From: [REDACTED]
To: [Norfolk Boreas](#)
Cc: [REDACTED]
Subject: Norfolk Boreas ExQ5
Date: 24 August 2020 16:06:21

My name is Chris Allhusen from Bradenham Hall Farms. We own the land on which the south-eastern end of the Norfolk Boreas sub-station will be constructed. This project will have a considerable detrimental effect on our Estate and farming operations, not only from a practical point of view, but also noise, visual effects and light pollution. I wish to make the following points on some of the questions, as follows –

Photomontage of the proposed Norfolk Boreas HVDC Substation with the National Grid Substation Extension and mitigation planting (15 years growth)

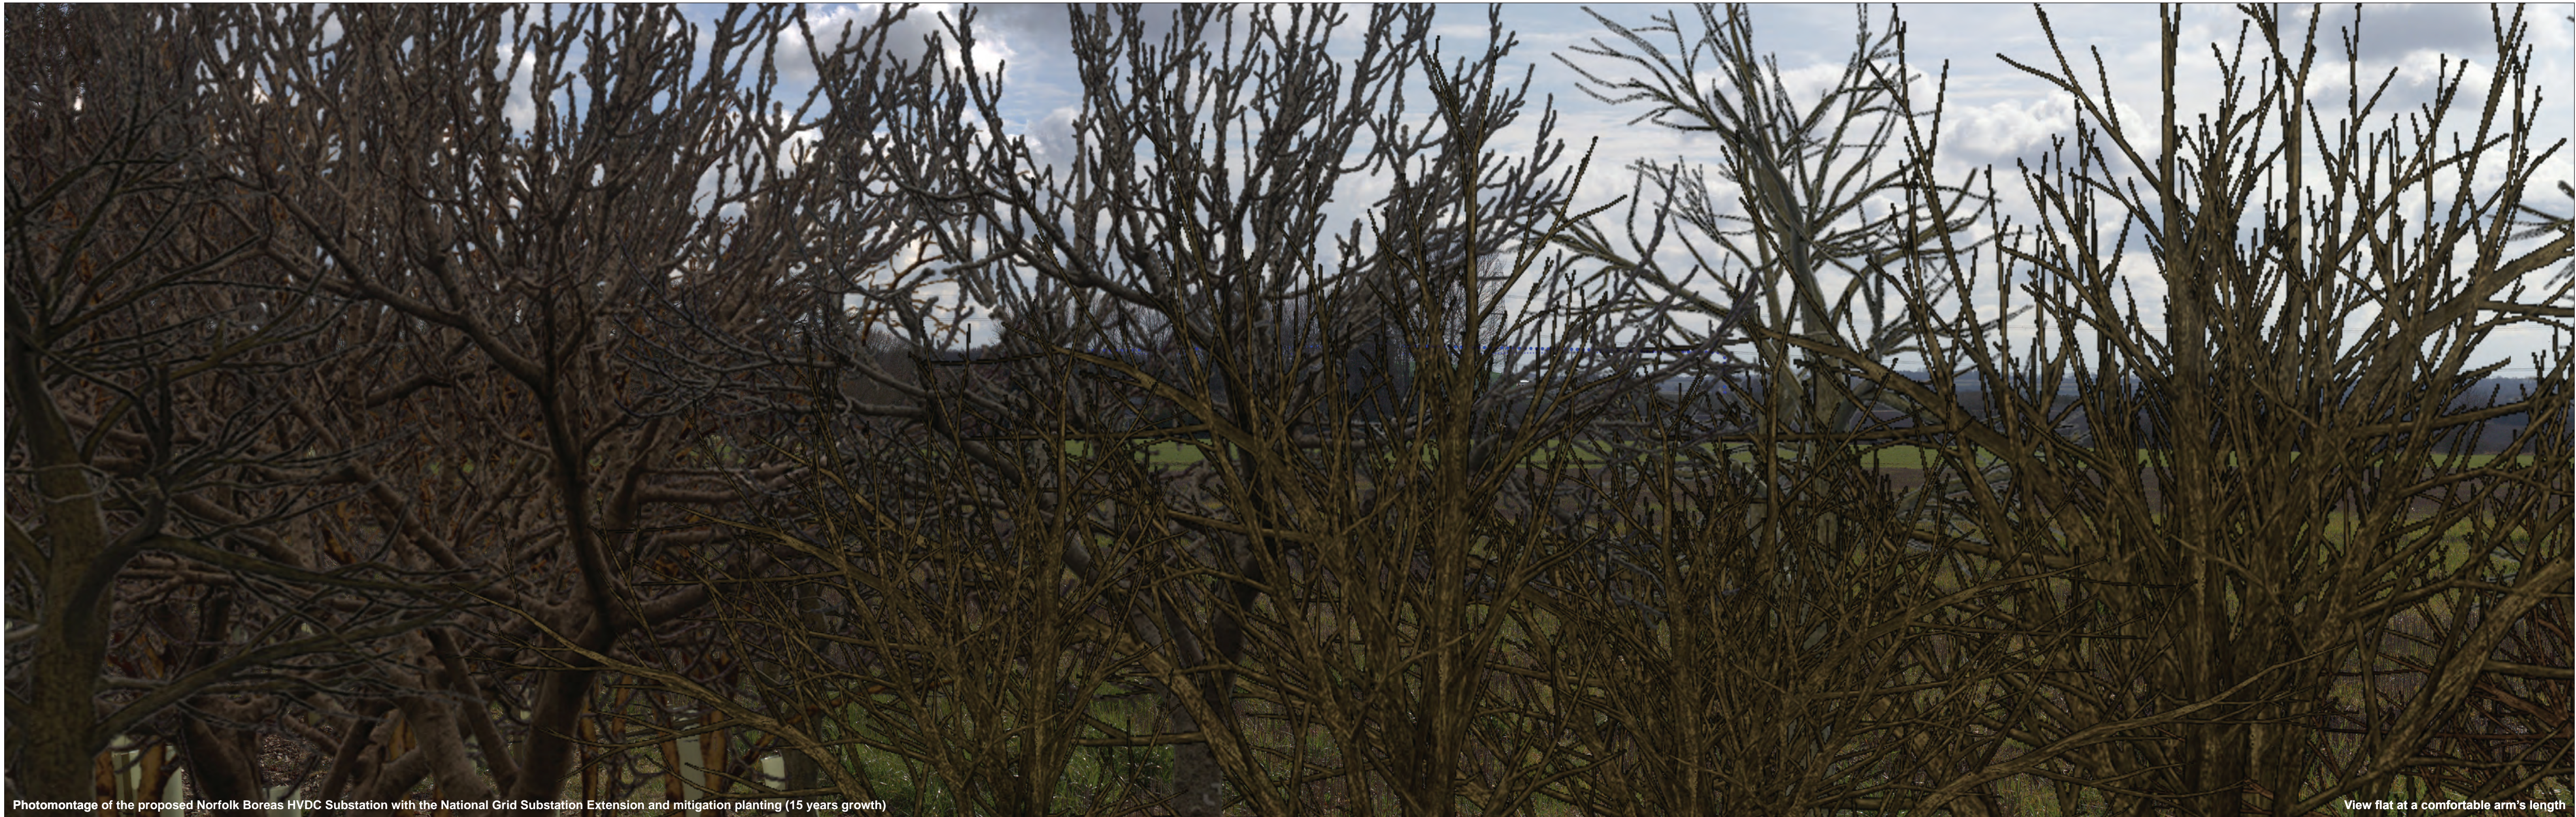
Tree Screening. The tree screening has been discussed but the current

plans show a screen of only 15 m wide. This would only allow for approx. 4 rows of trees, almost totally ineffective. In my experience this should be 30 metres wide and on both the south east and north east sides. Whilst I have been in contact with the Jo Phillips, Boreas's ecologist, I have not had any assurances from Boreas that what we agree will happen. In addition, for any trees to have the slightest possibility of screening these buildings, they will need to be of a considerable age and height when planted and not very small whips.
